RE: 6/2019/1788/COND – Former Shredded Wheat Site, Broadwater Road, Welwyn Garden City, AL8 6UN

Thank you for consulting us on the above application for the submission of details pursuant to condition 5 (Surface water Discharge) 6 (Drainage System) 52 (Provision of open space/play space) 35 (Delivery of accessible Housing) 13 (Highways) 37 (Vehicle access Point to Pall Mall Site) 50 (Refuse Storage Arrangements) on planning permission 6/2018/0171/MAJ, at Former Shredded Wheat Site, Broadwater Road, Welwyn Garden City, AL8 6UN.

SuDS Officer

Dig Title: **PROPOSED CONSTRUCTION DETAILS PHASE 1**

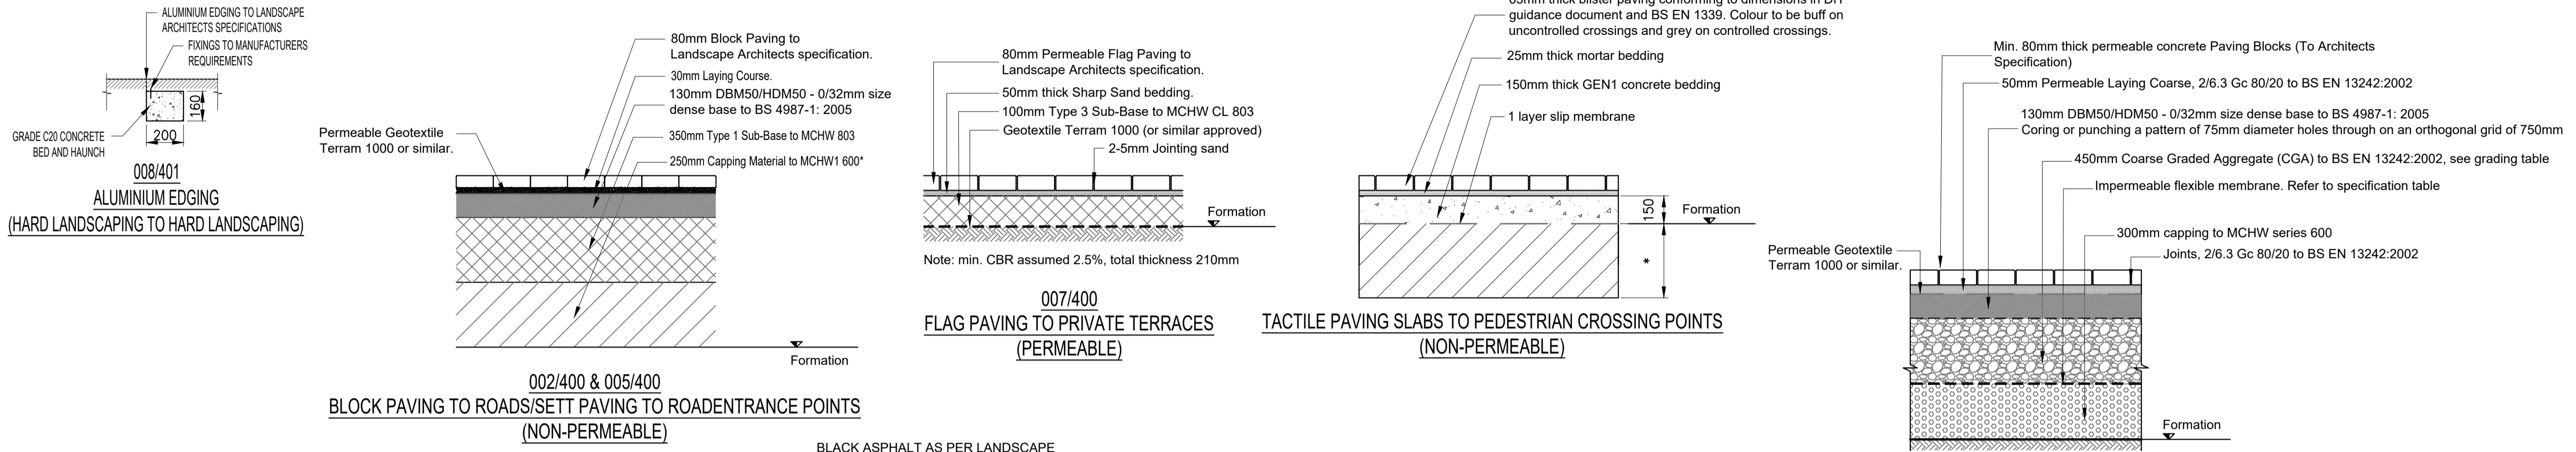
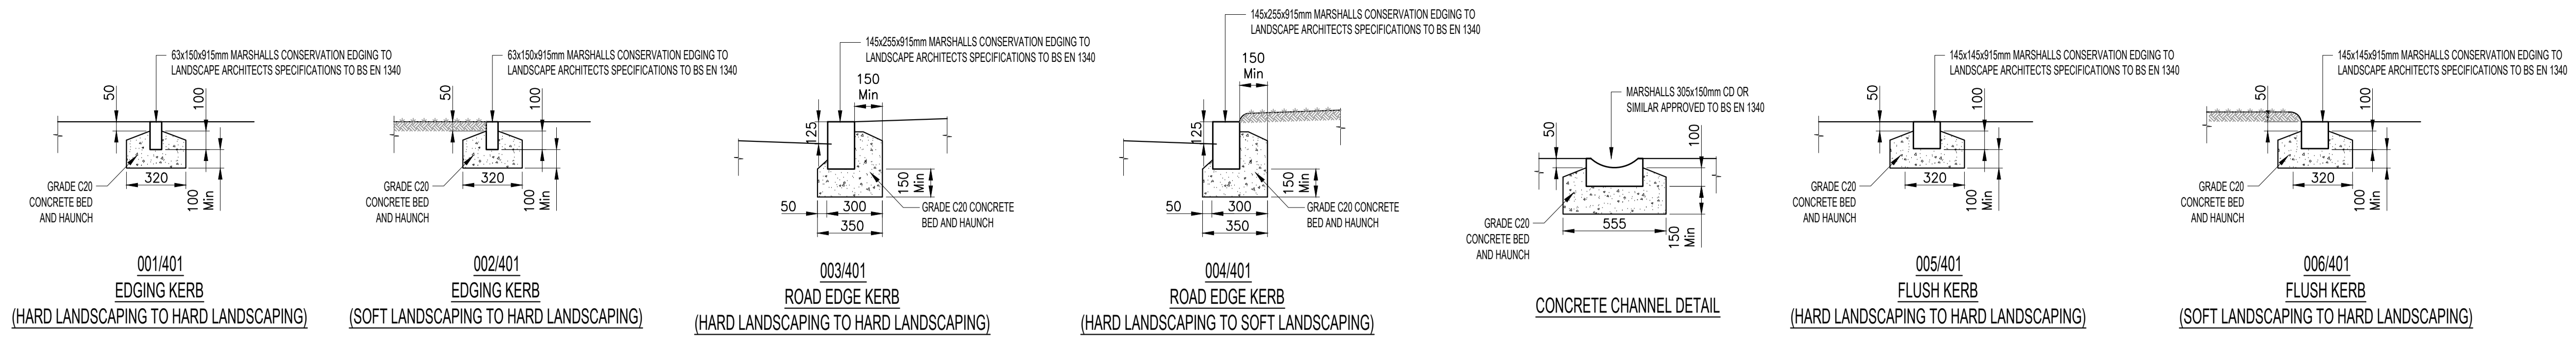
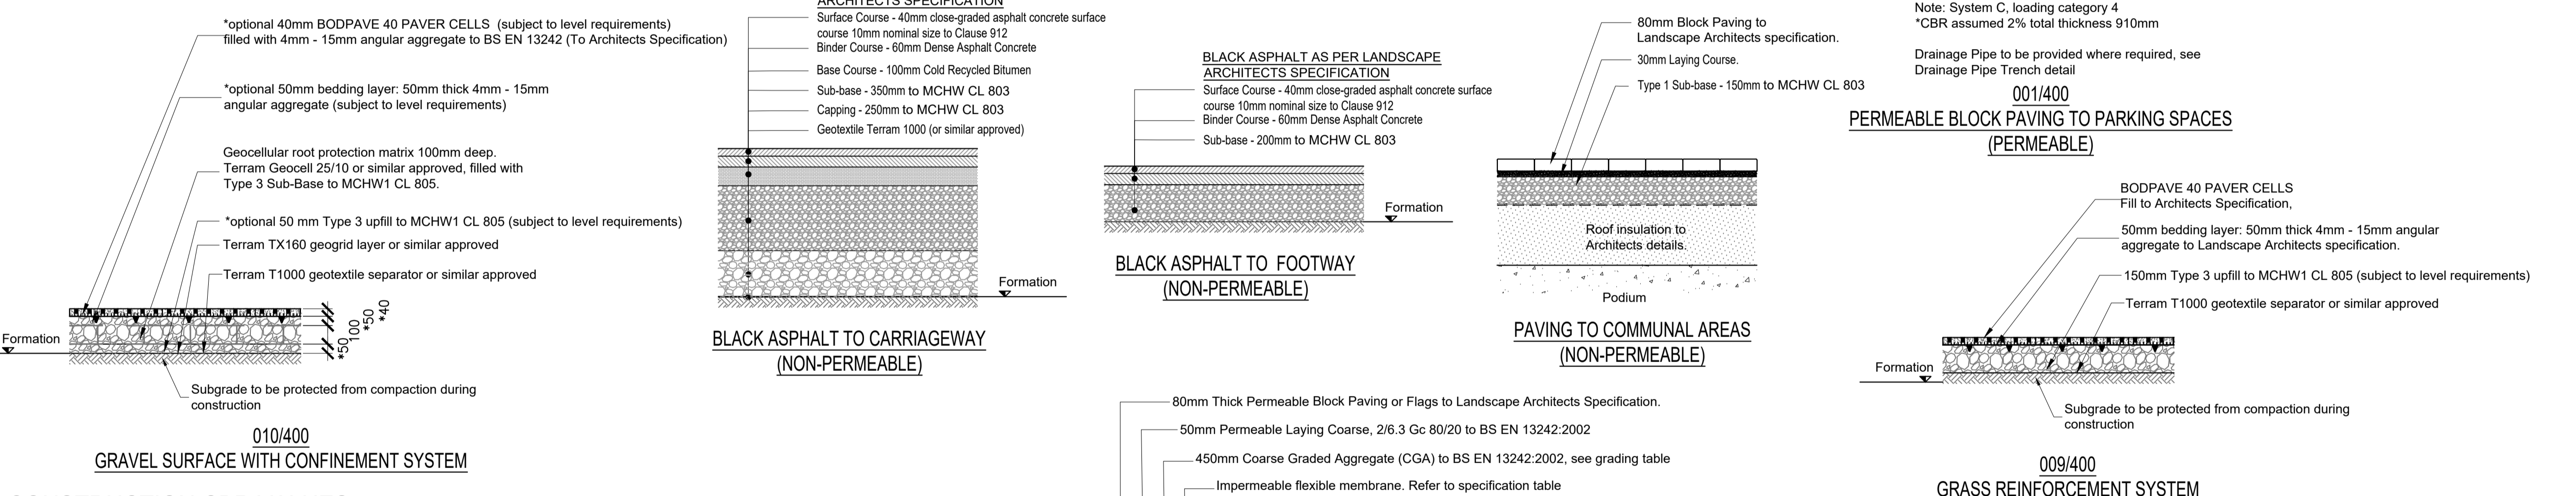
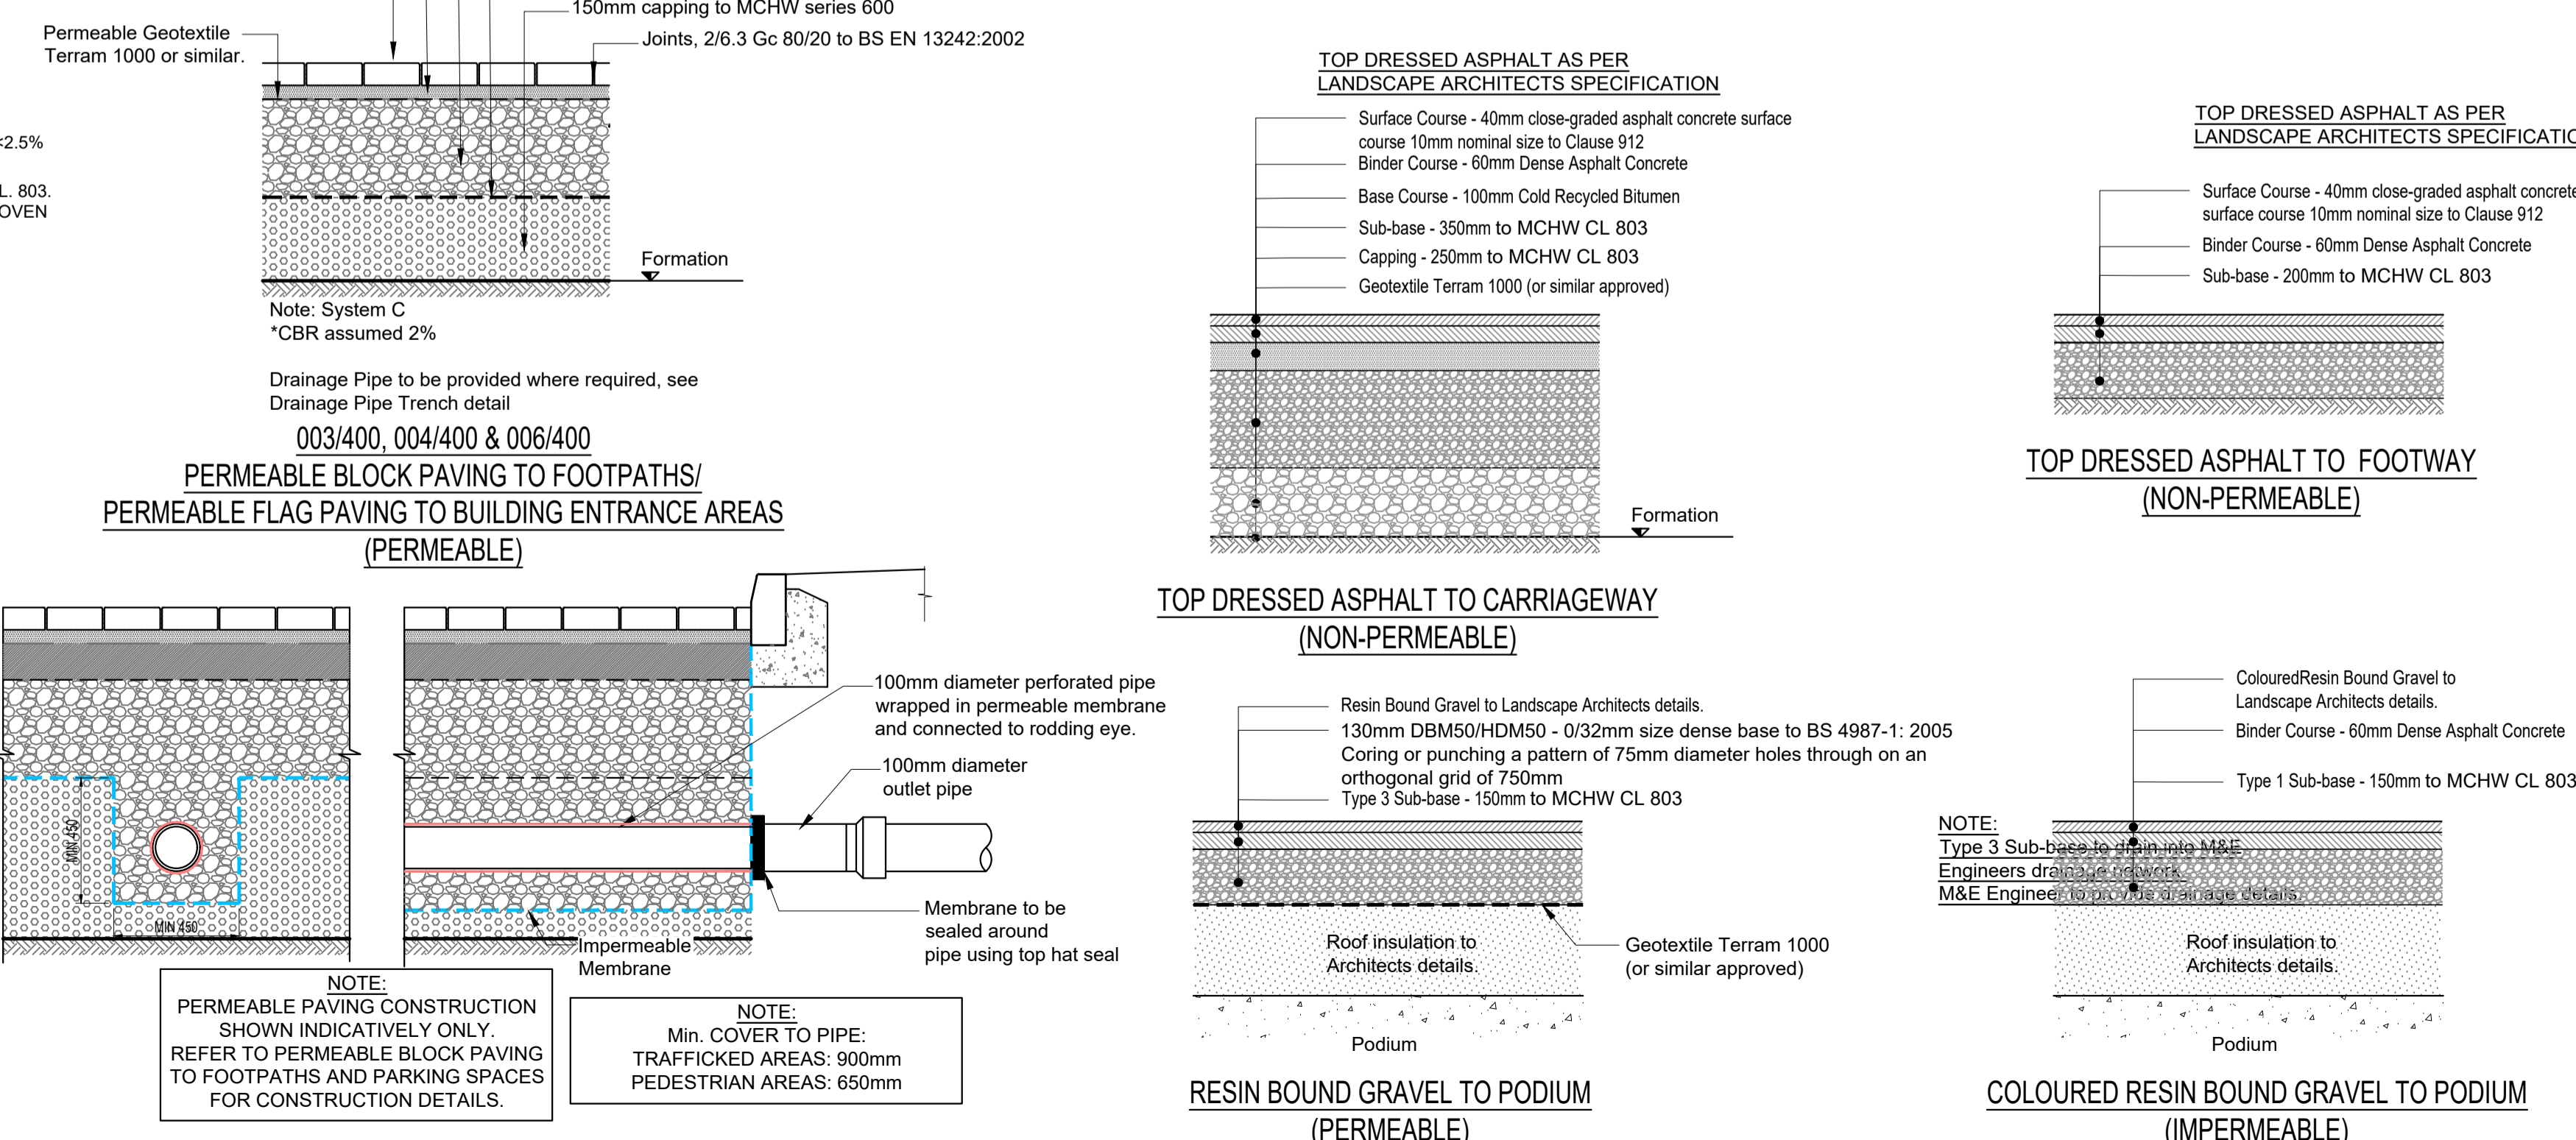
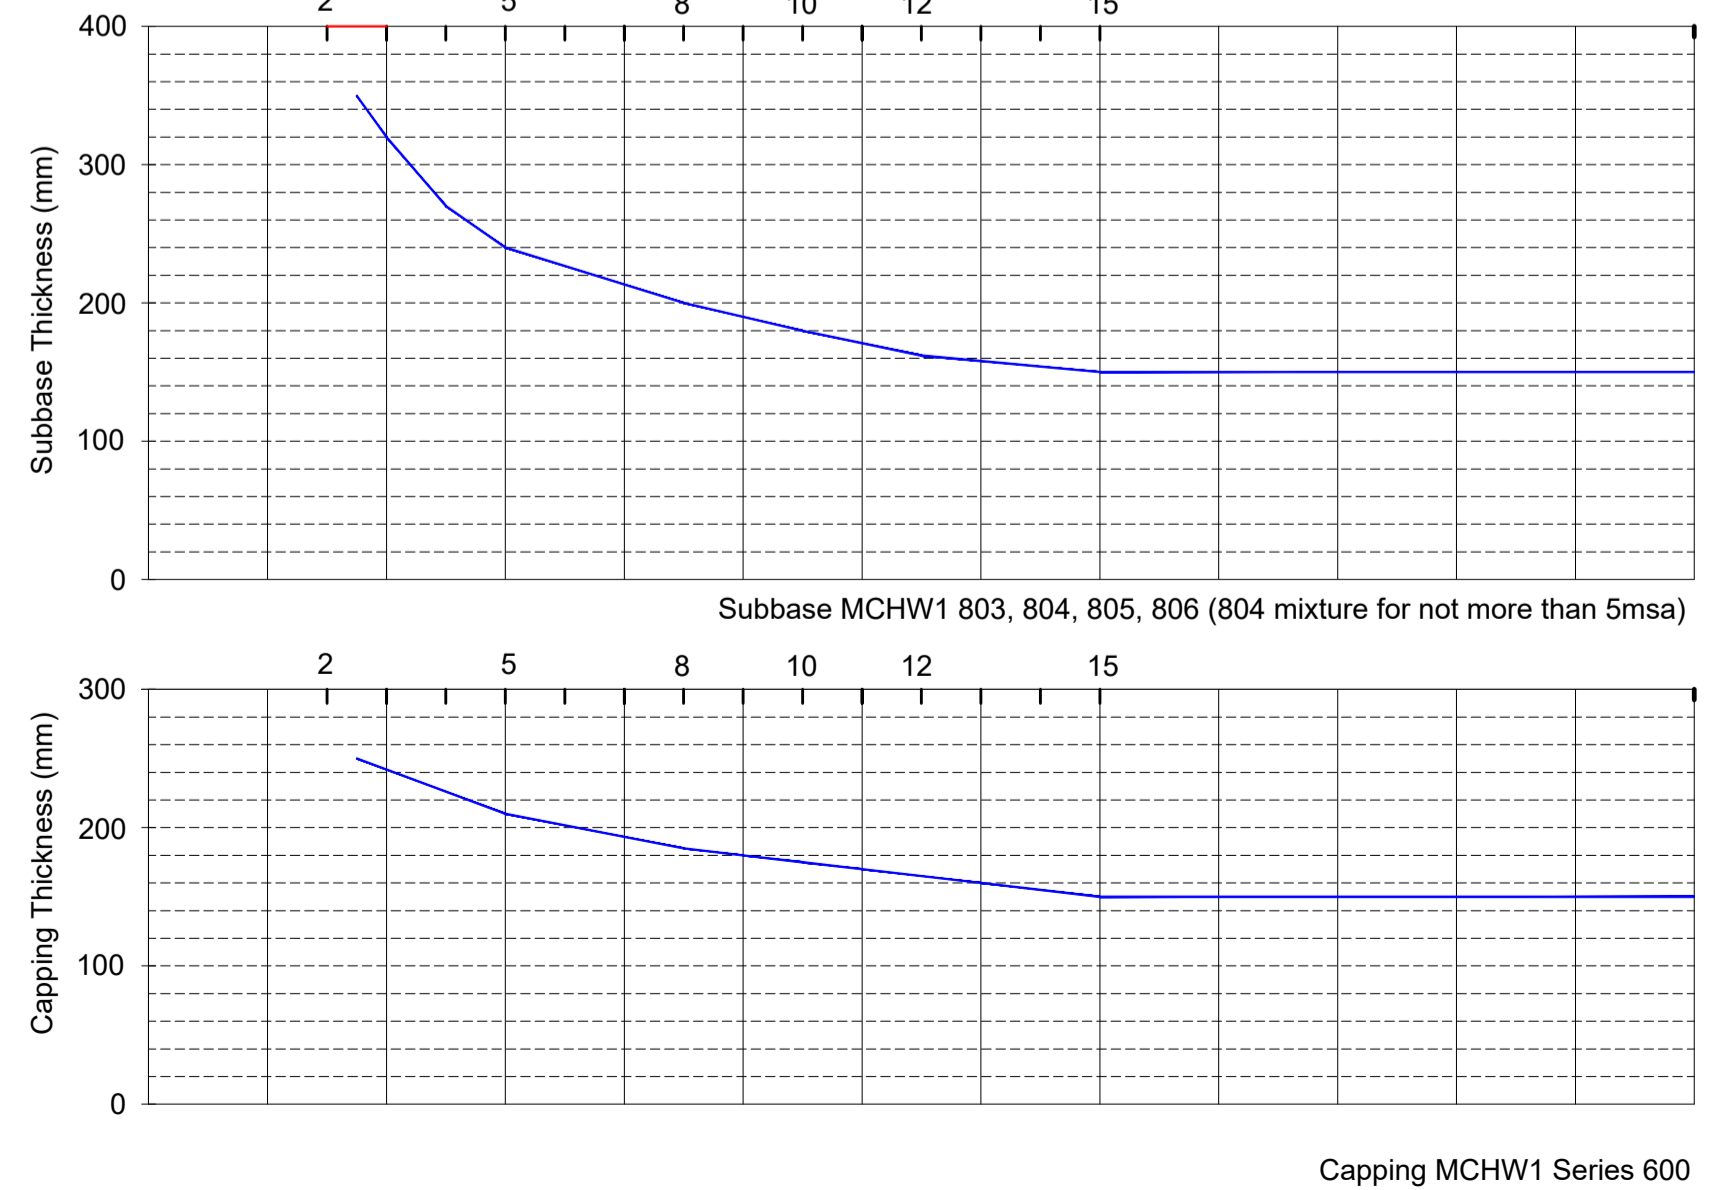
No detailed engineering drawings of the proposed tanks and dry swales have been provided.

PROPOSED DRAINAGE LAYOUT (PHASE 1)

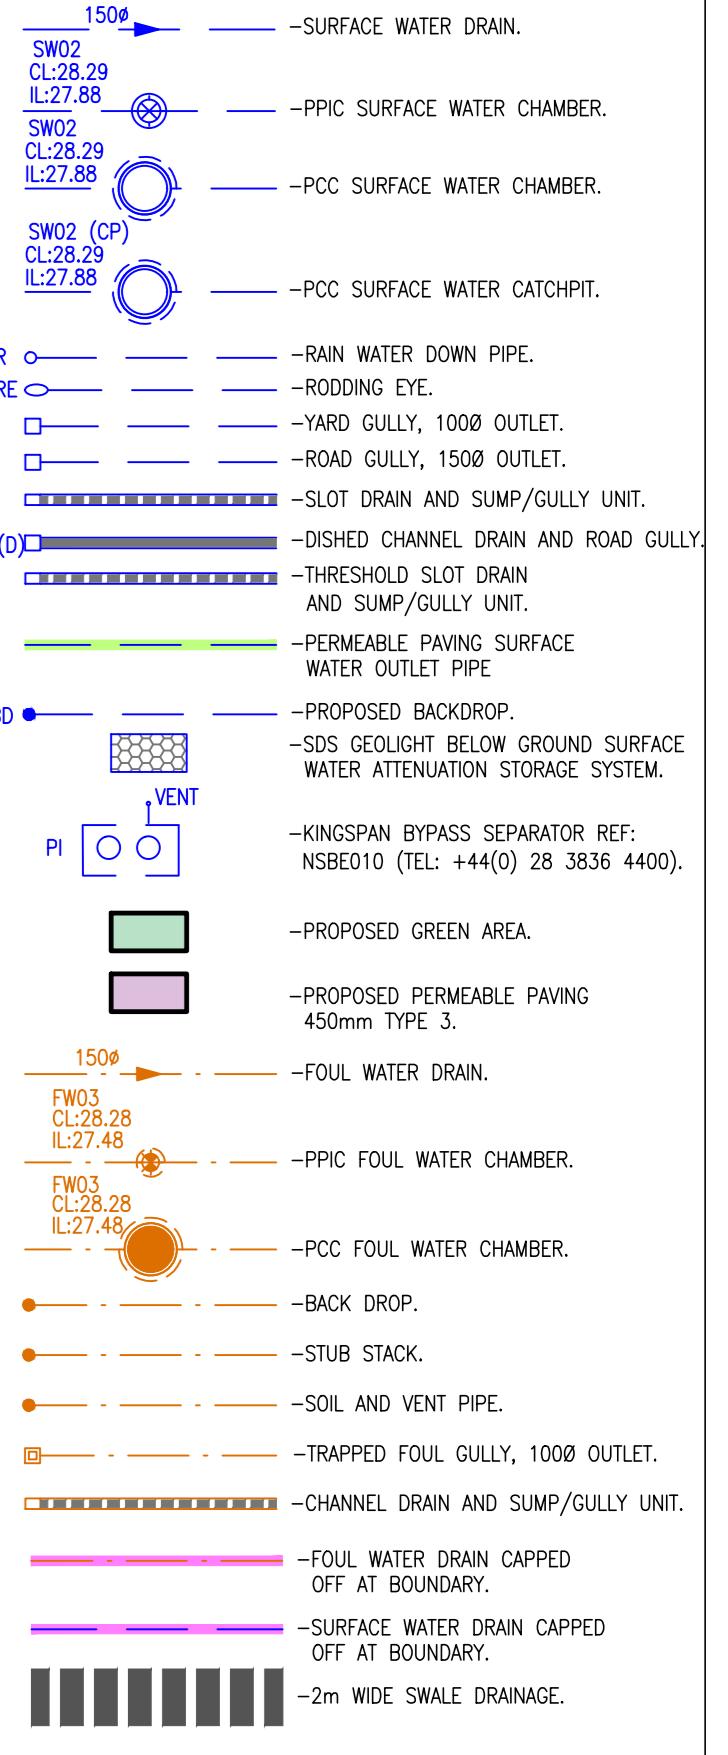
We note that the applicant has submitted an updated, detailed drainage plan. We have noticed that new discharge points are being proposed for sub-catchment 1.

However, no detailed information has been provided for the new discharge points. Invert levels of the connection points into the public sewer need to be confirmed at this stage.

We would advise that Greenfield run-off rates should be estimated for the development site. The final discharge rate from the site should be limited to Greenfield run-off rates.

No confirmation of the available sewer capacity study results has been provided. Moreover, based on the submitted letter from Thames Water dated 12th August, our understanding is that there is no agreement for the proposed discharge rates and volumes at the proposed locations.

Attenuation and storage volumes provided for the entire site need to be identified. Based on the submitted information, only storage volumes of the proposed four underground tanks have been provided as this stage.

Based on the review of the submitted information, we have noticed multiple drainage network connections coming from outside of the development site or new connections coming towards the site drainage network. This means that the sub-catchment approach has not been met. We would advise that this should be clarified by the applicant.

Moreover, full modelling for this drainage sub-catchment should be provided with all additional connections included.

We would advise that full details of two overflow basins/ dry swales located to the south west from the development site should be provided, as they will provide significant storage volumes for the development site.

Total storage volumes for this drainage sub-catchment should be provided. Moreover, drain down times for all storage features have not been provided.

It should be clarified and demonstrated why underground storage features have been included in the proposed strategy. At this point major storage volume has been provided in underground tanks.
